WEST SUSSEX COUNTY COUNCIL CONSULTATION

TO:	Arun District Council FAO: Amber Willard
FROM:	Highways, WSCC
DATE:	12/12/2018
LOCATION:	Florabunda, Bilsham Road, Yapton, BN18 0JN
SUBJECT:	Y/78/18/HH Vehicular access.
DATE OF SITE VISIT:	N/A
RECOMMENDATION:	☒ Advice ☐ Objection ☐ Modification ☐ No Objection ☐ More Information ☐ Refusal
S106 CONTRIBUTION TOTAL:	£N/A

Flora Bunda, Bilsham Road, Yapton, Arundel

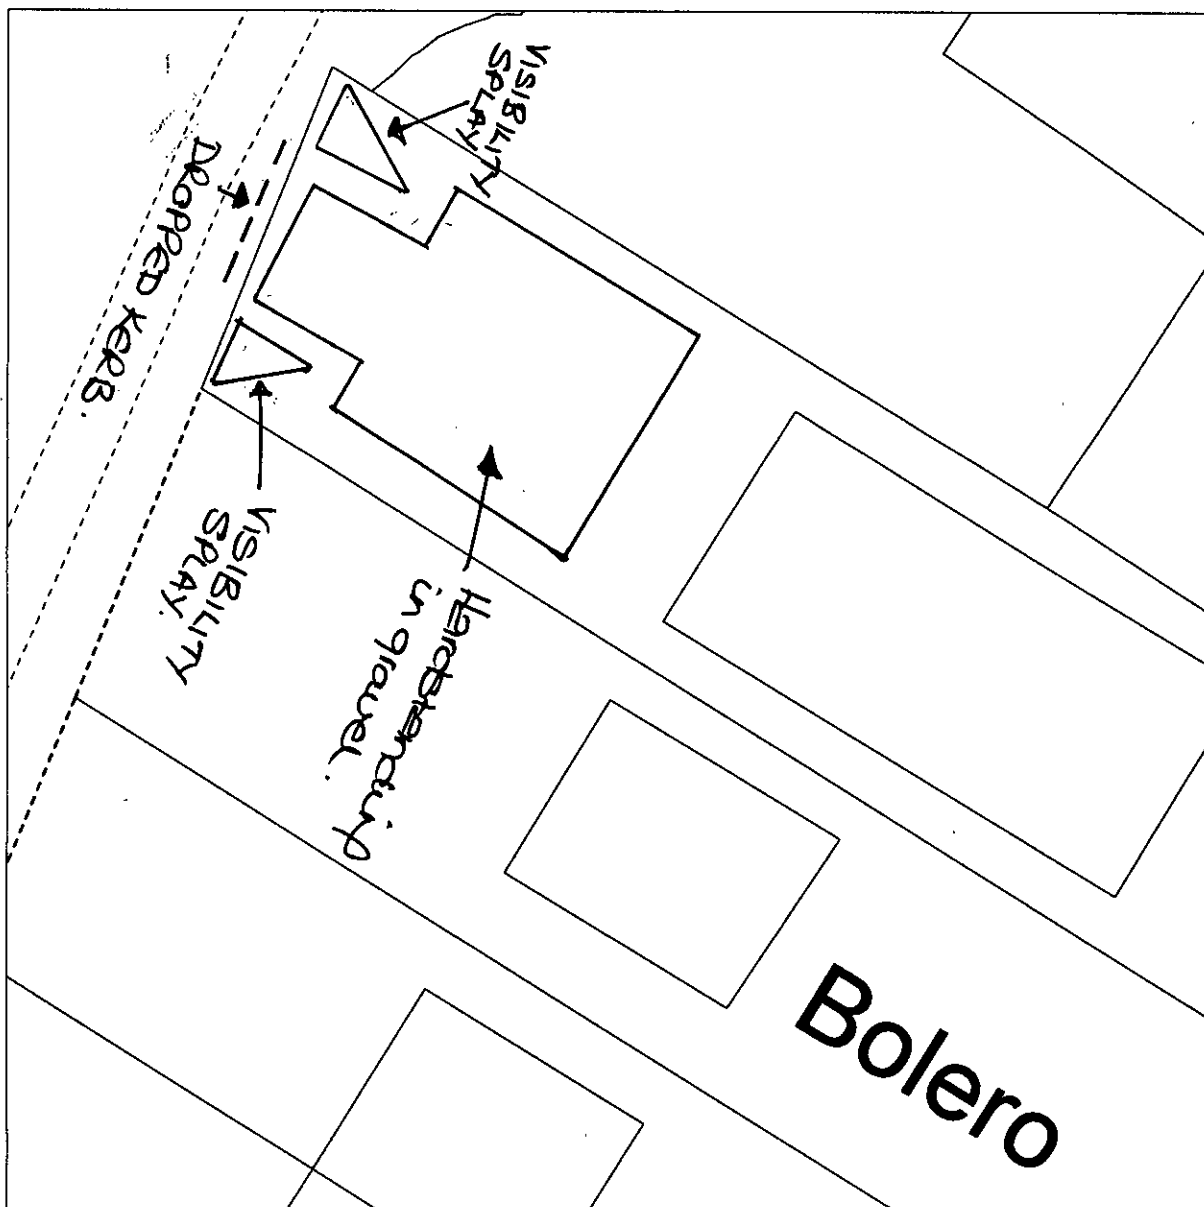
The proposed plans indicate that the proposed VCO will be approximately 4m in width. A licence will be required for the proposed access and must be constructed to a specification agreed with the Local Highway Engineer.

The proposed plans demonstrate pedestrian visibility splays, however these do not appear to have been drawn to WSCC standards. Due to the proximity of the site to bus stops and local shops and services, there is a benefit to ensuring that pedestrian visibility is maintained. Pedestrian visibility splays should be taken 2m back into the access and a distance measured along the back of the footway for 2m on each side of the access, as demonstrated below. There should be no obstructions over 0.6m within these splays. Details of pedestrian visibility can be secured via condition.

The proposed plans indicate that parking for two vehicles will be provided on site. The proposed area of hardstanding meets the minimum specifications of 2.4 x 4.8m per parking space as set out in Manual for Streets. A turn on site would be preferred however neighbouring properties operate similar arrangements without evidence of safety concern.

No part of the development shall be first occupied until pedestrian visibility splays of 2 metres by 2 metres have been provided either side of the proposed site vehicular access onto Bilsham Road in accordance with plans and details to be submitted to and approved in writing by the Local Planning Authority. These visibility splays shall thereafter be kept free of all obstructions over a height of 0.6 metre above adjoining carriageway level or as otherwise agreed.
